Catherine Field Primary School Mod 2 Additional Information – 19th November 2020

SECTION 4.55(1A) MODIFICATION APPLICATION, NEW CATHERINE FIELD PUBLIC PRIMARY SCHOOL (SSD 9477 – Mod 2) – ADDITIONAL INFORMATION

We refer to the Department of Planning, Infrastructure and Environment (DPIE) request for additional information dated 10th November 2020 relating to matters raised by Camden Council. The following information re-states the matters (in *italics*) and provides a response to each.

AMENDMENTS				DESCRIPTION
REV	BY	DATE		
A	AC	17.09.20		ISSUE FOR SSDA - ADDED TEMPORARY CAR PARK ACCESS, AMENDED KISS & DROP

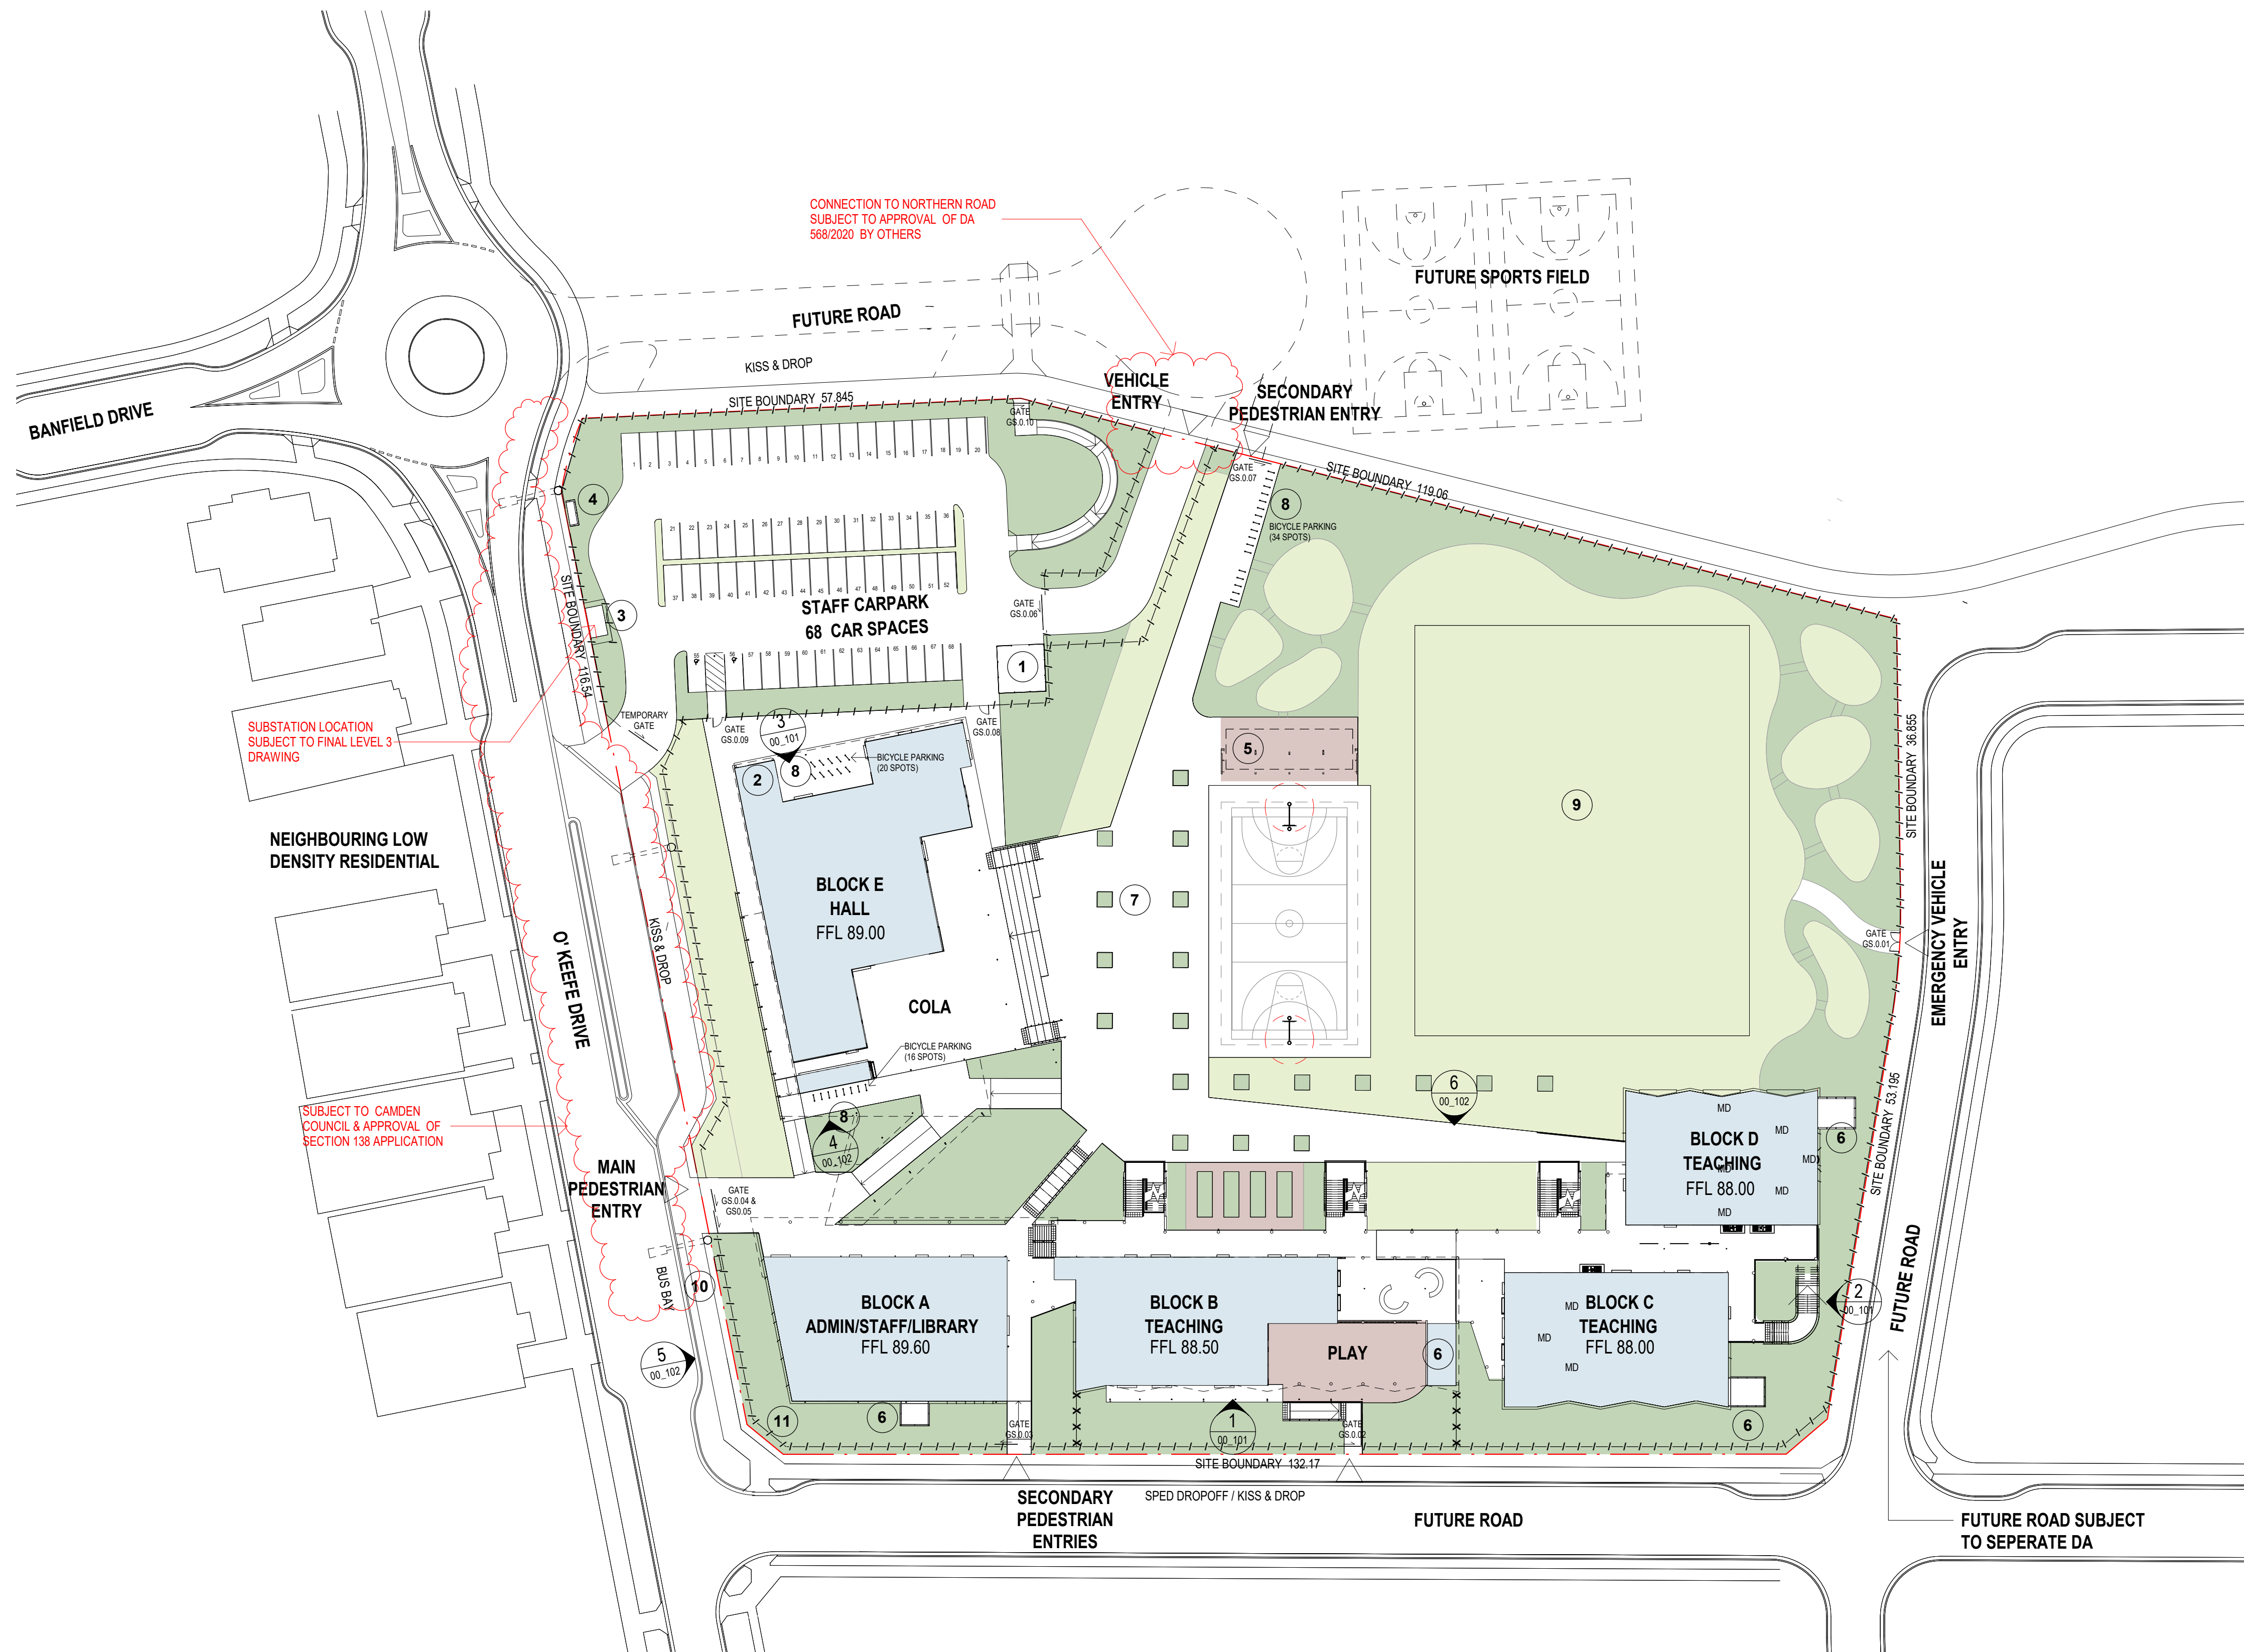
1. *Swept paths shall be submitted showing vehicles entering and exiting the interim car park access*

2. *Sightlines at the interim access shall be assessed – the driveway is angled and setback, also it's not clear if trees will be planted adjacent to the driveway*

3. *Queuing at the Kiss and drop area may obstruct the interim driveway particularly during pick-up and drop off periods.*

A swept path plan for a 10.24m waste truck and a swept path plan for B85 and B99 design vehicles are contained in **Appendix A**. The plans have been prepared by Anson Group and indicate that these vehicles will be able to enter and exit the interim car park access in accordance with the requirements of the relevant Australian Standards.

Street trees will not be planted either side of the connection point of the temporary access with the bus and special needs student drop off area. Mass planting will occur within the school site including along the fence line of O'Keefe Drive. Sufficient sightlines will be afforded to vehicles entering and exiting the car park.

The area referred to as a "kiss and drop off area" is in fact not to be used for this purpose. The area will be used for buses and drop off for special needs students on a periodic basis. The interim driveway will connect with the northern extent of the bus and special needs student drop off area. Usage of the bus and special needs student drop off area will not be as frequent as usage as a general drop off and pick up area and hence queuing is not anticipated.
